LSC TRANSPORTATION CONSULTANTS, INC.
545 East Pikes Peak Avenue, Suite 210
Colorado Springs, CO 80903
(719) 633-2868
FAX (719) 633-5430
E-mail: lsc@lsctrans.com
Website: <http://www.lsctrans.com>

MEMORANDUM

SUBJECT: Lorson Ranch East
(PUDSP-16-003) Review 2
Response to Comments Memorandum
LSC #164360

Following are the LSC Transportation Consultants, Inc. responses to the August 15, 2017 El Paso County Planning and Community Department comments letter regarding the July 12, 2017 Updated Traffic Impact and Access Analysis by LSC.

Lorson Ranch East Roundabout (LSC #164360)

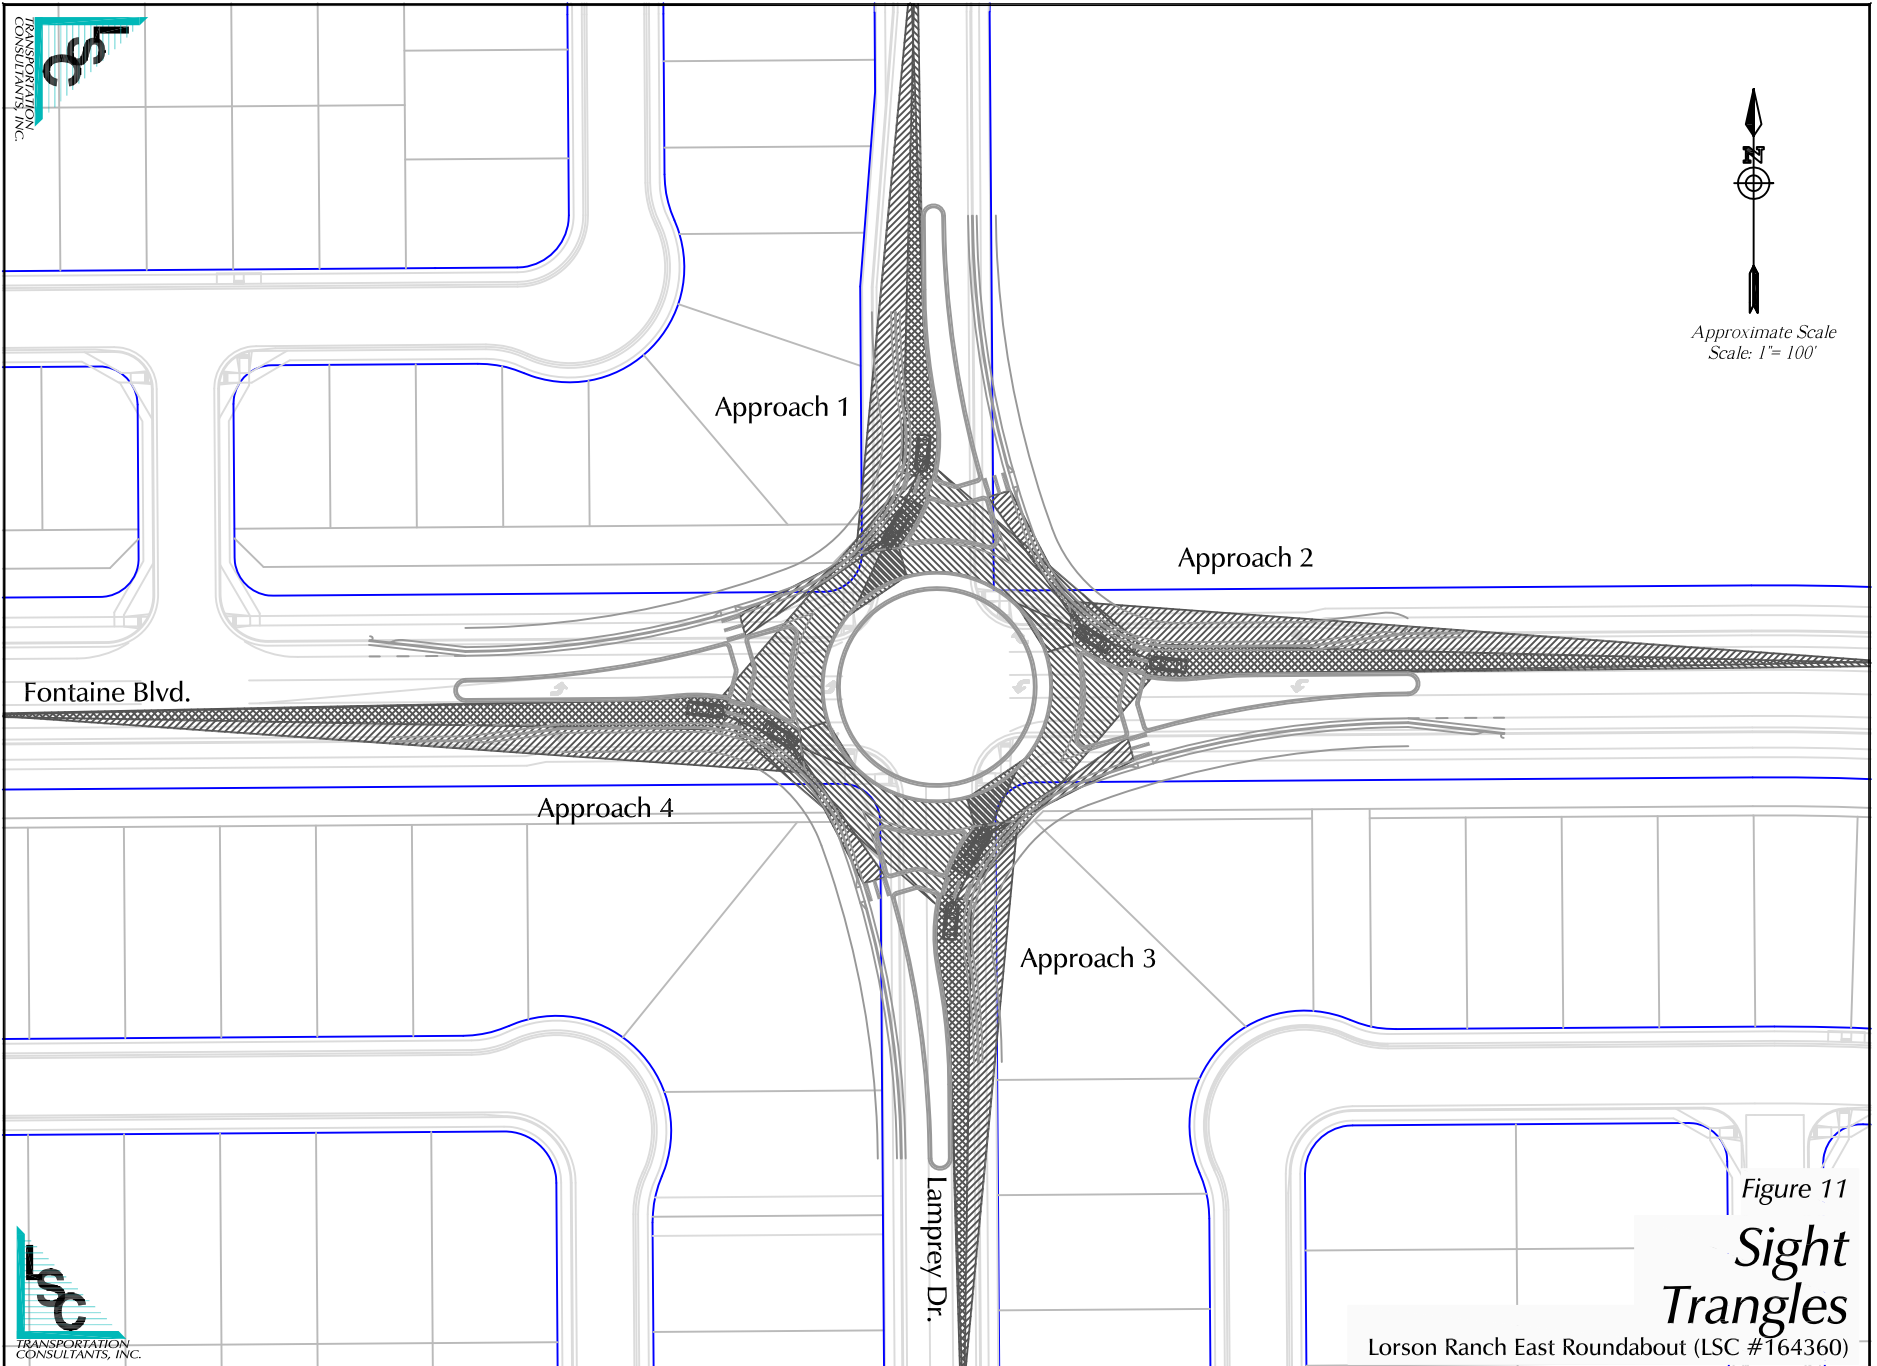
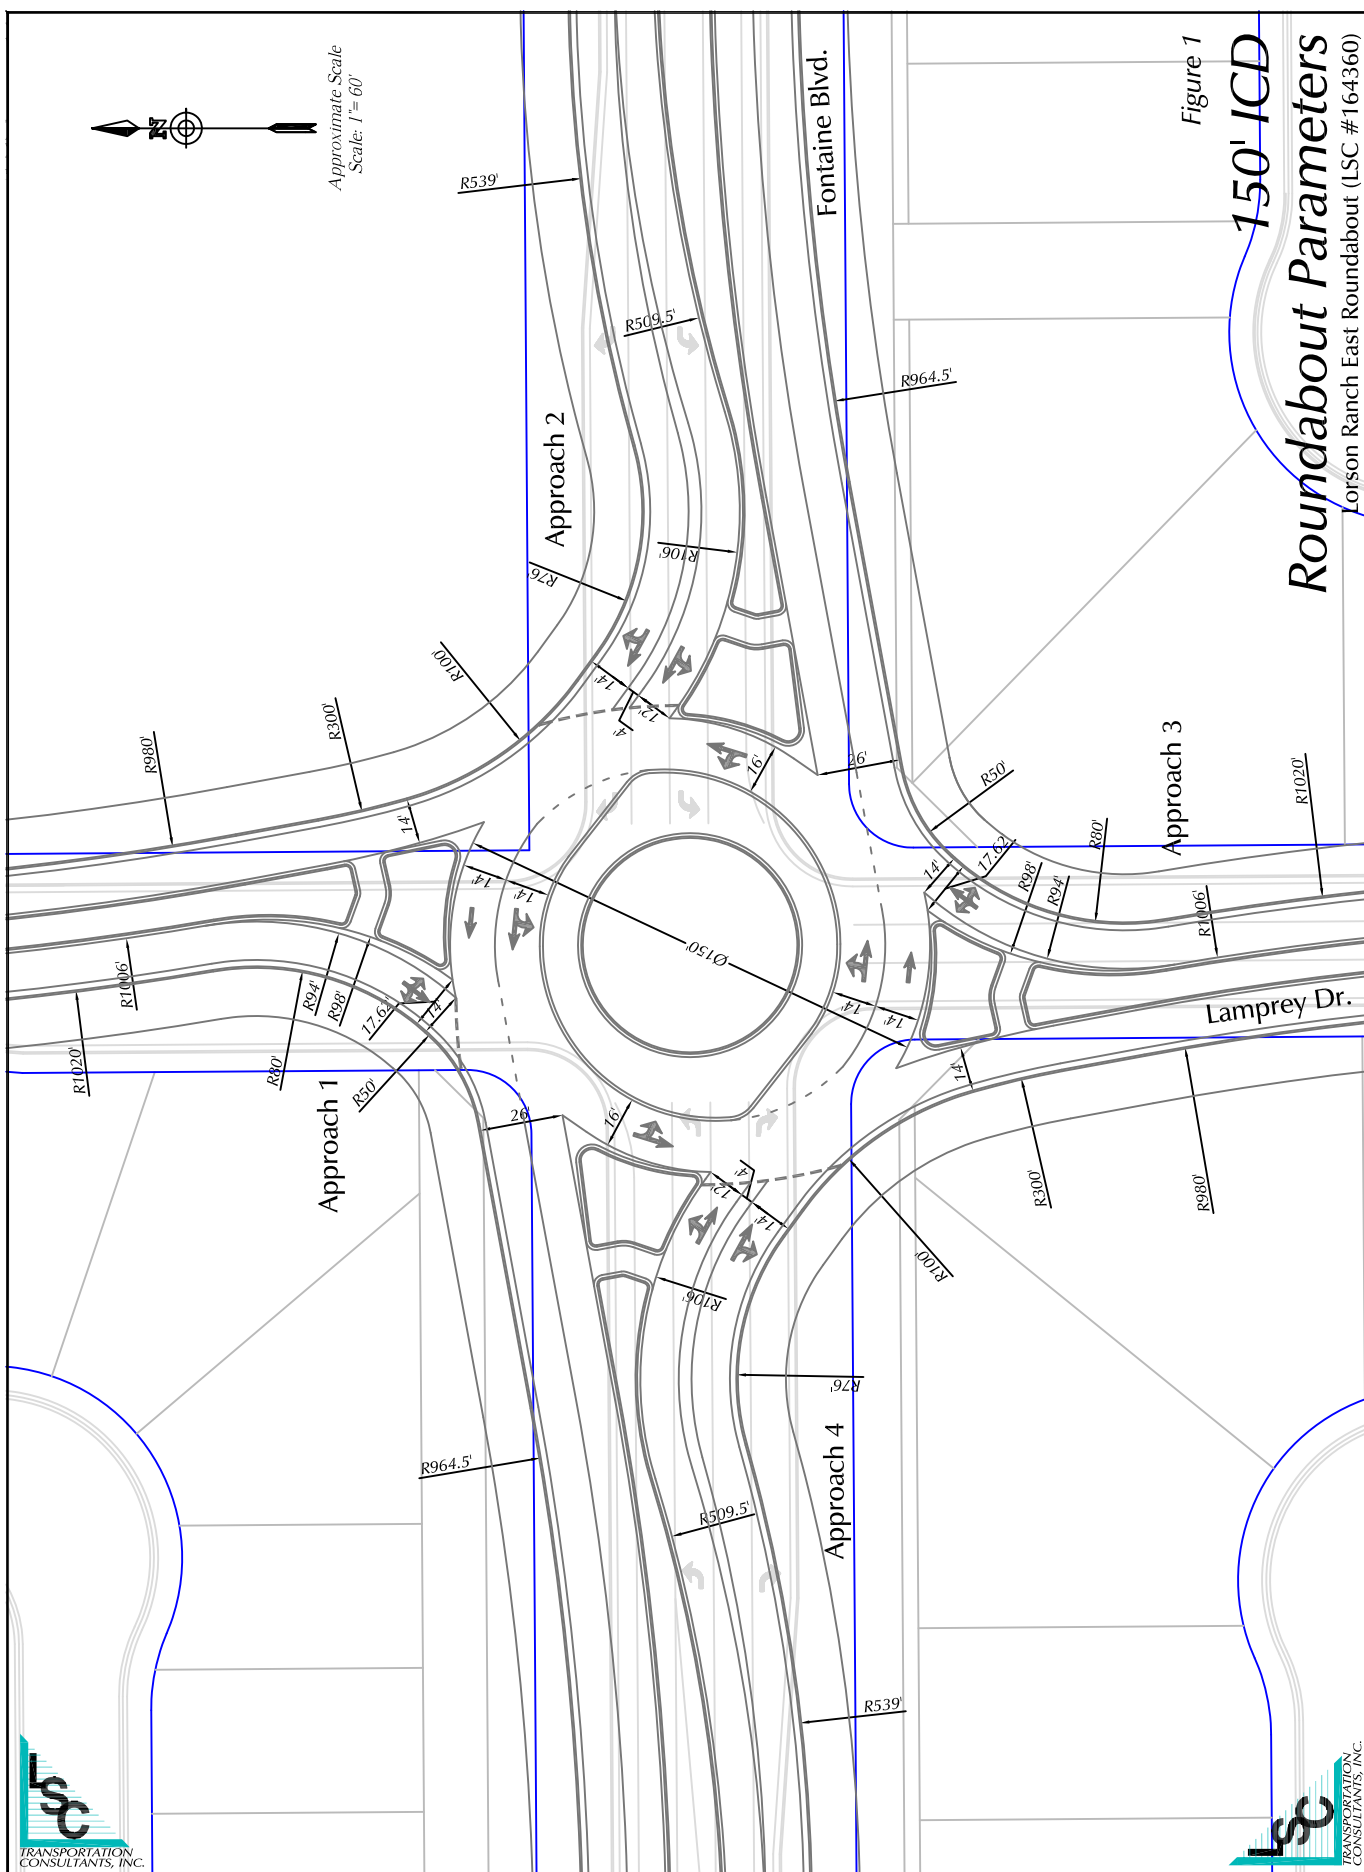
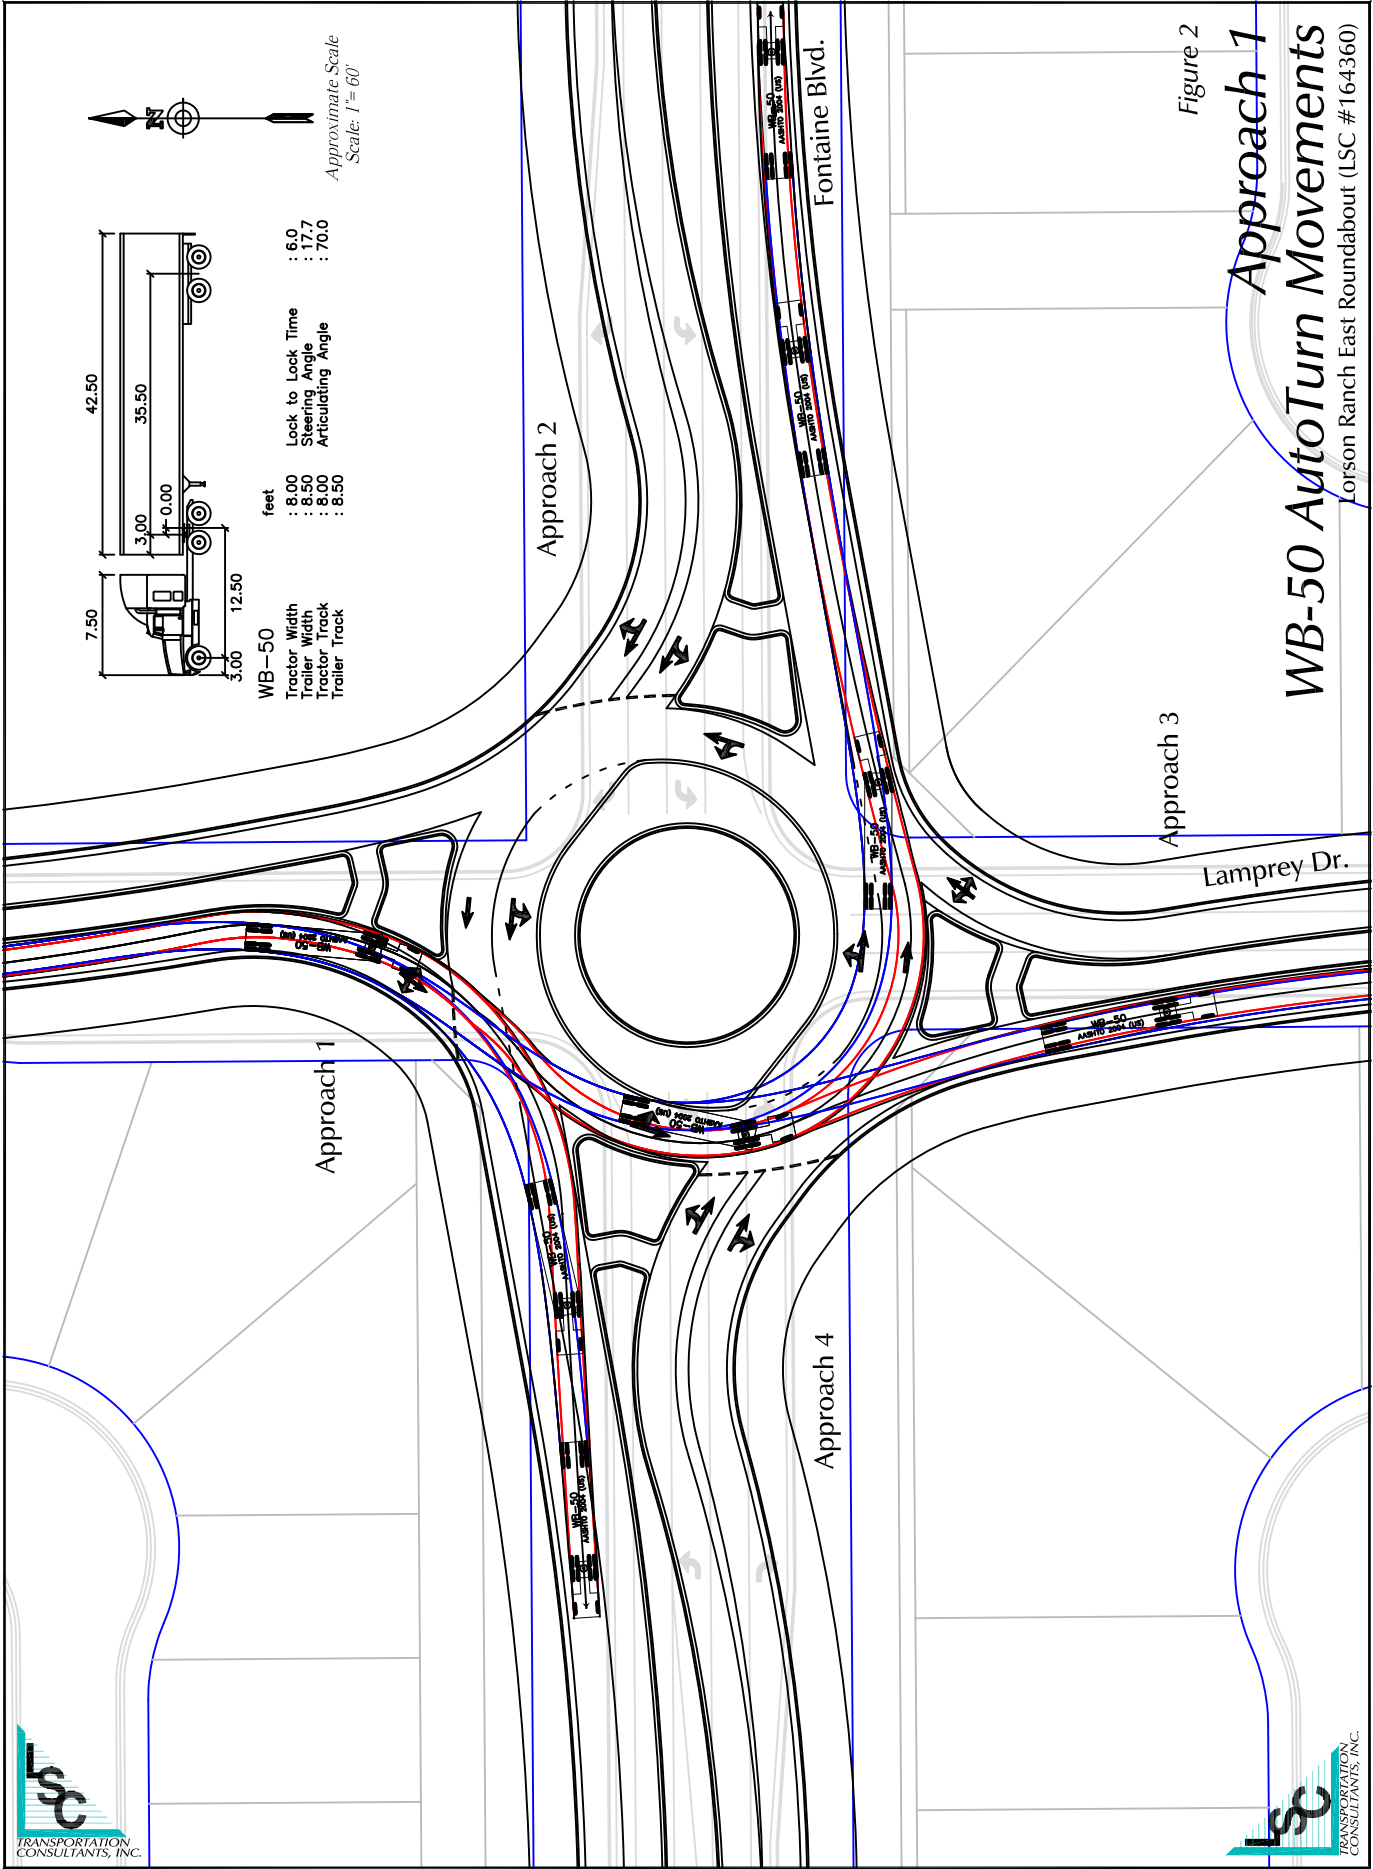
8. *Regarding the e-mailed comments dated March 17, 2017:*
*a. **It needs to be clearly documented that the roundabout is the proposed intersection at Lamprey/Fontaine. If the roundabout is the chosen option, could it not be designed to be expandable to 2-lanes when necessary along with widening of Fontaine Blvd.?***

LSC Response: The updated TIS clarifies this and clearly presents the roundabout as the proposed solution. The report also includes a roundabout design report and exhibits with the design of a future two-lane roundabout.
